Application for a non-material amendment following a grant of planning permission.

Two storey side extension including demolition of existing garden room.

Reference number: BR/35/19/HH & BR/36/19/L

WEST ELEVATION
 Dwg. No. 599-108

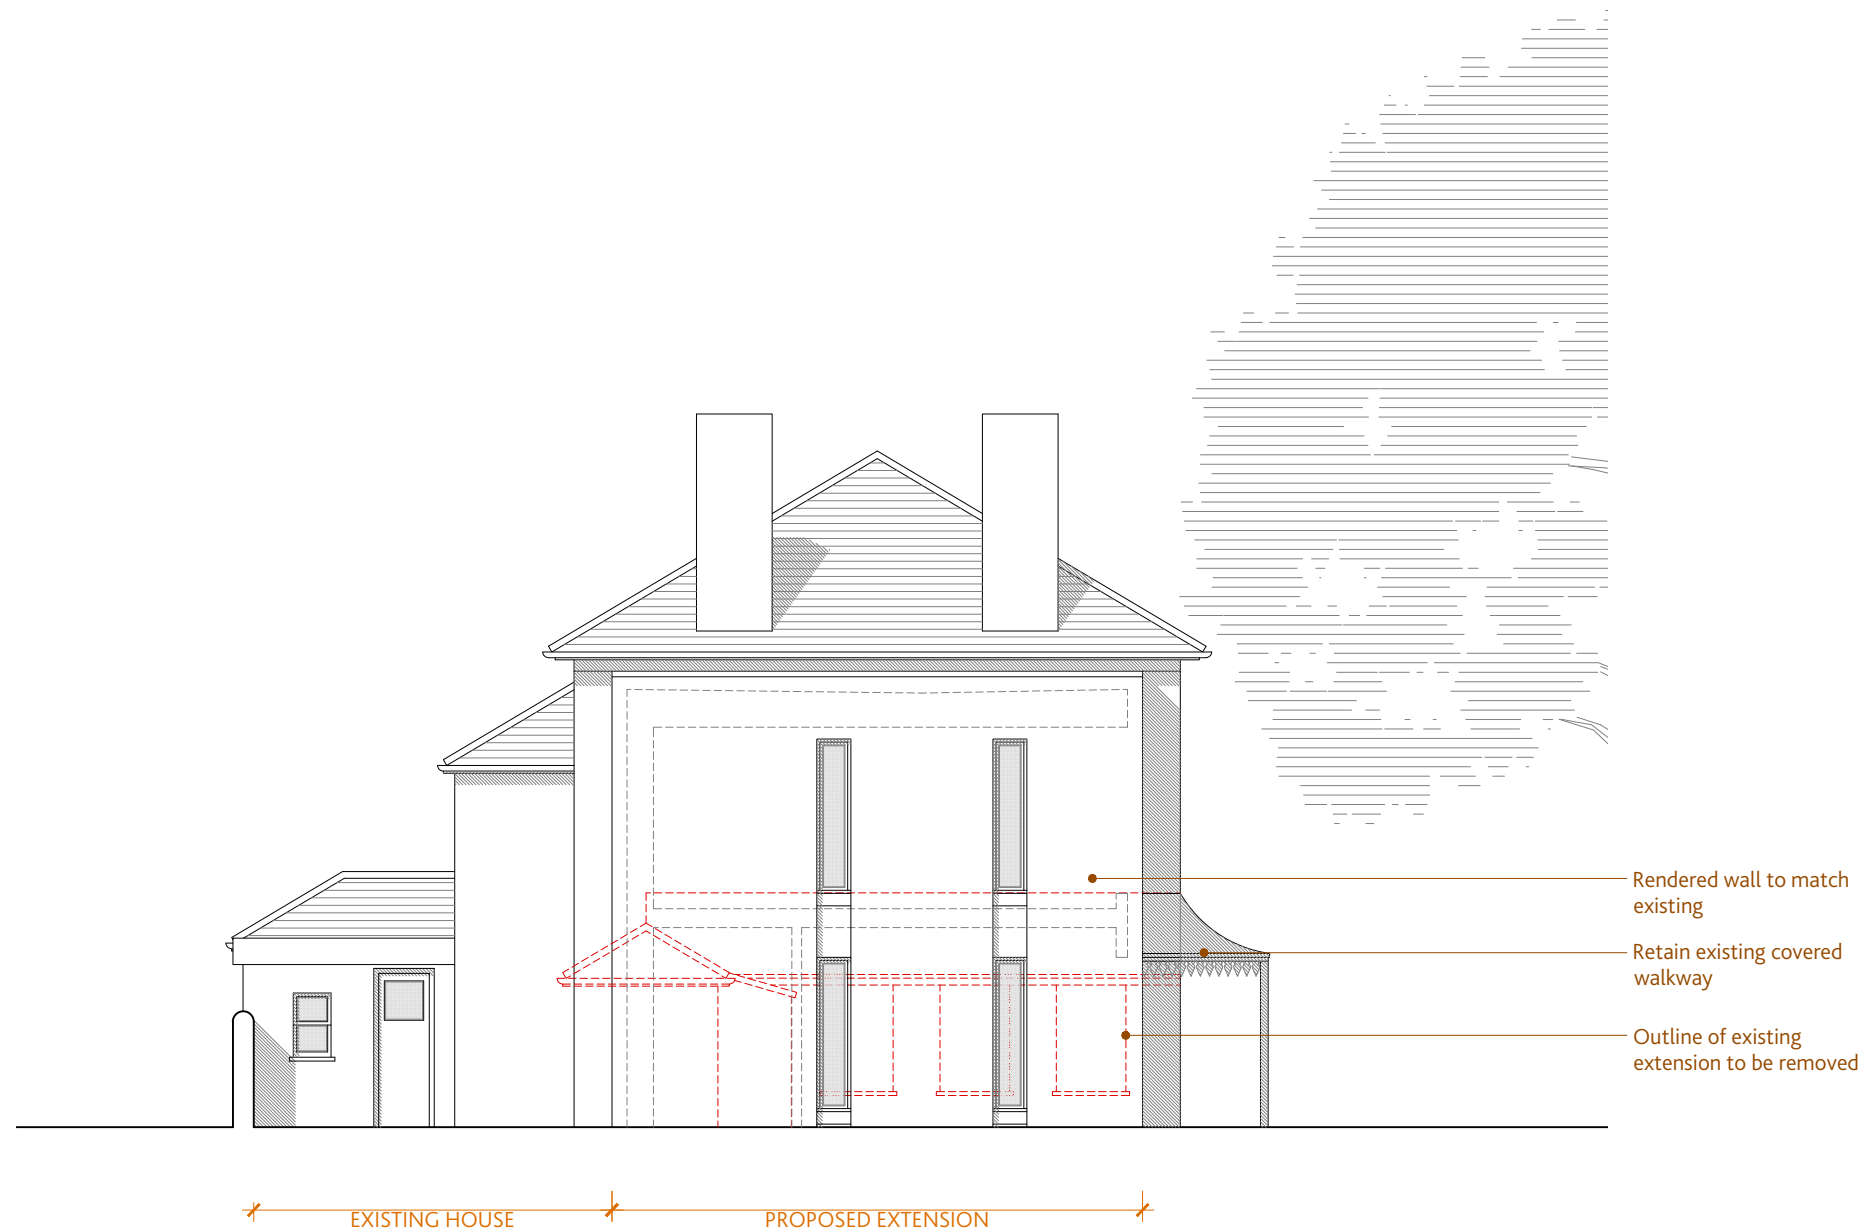
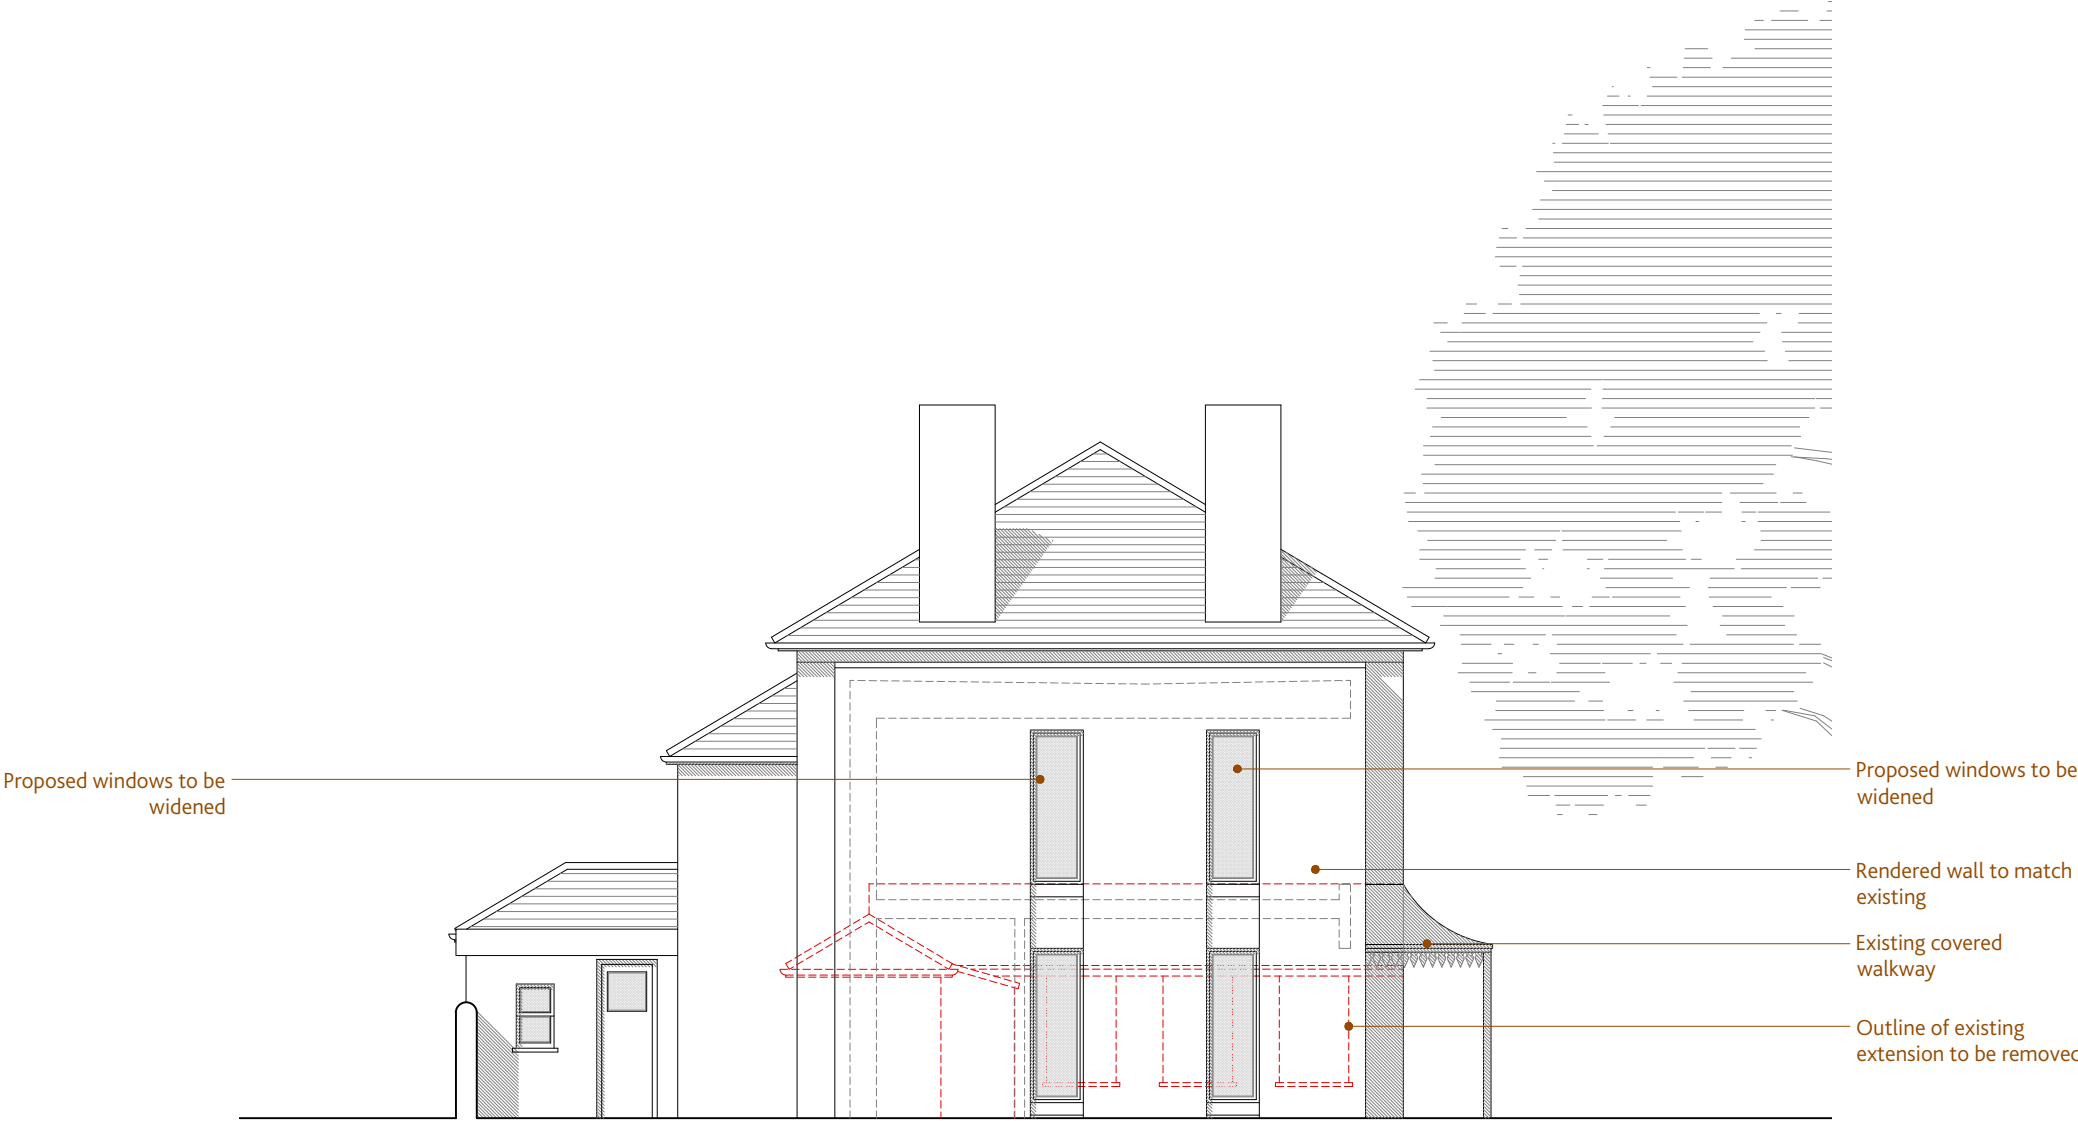
Amendments to the west elevation to indicate the 4 no. west facing windows having an increased structural width from 450mm to 700mm. There will be no change to the permitted window heights.

Proposed change to increase the amount of natural daylight into the depth of the proposed plan.
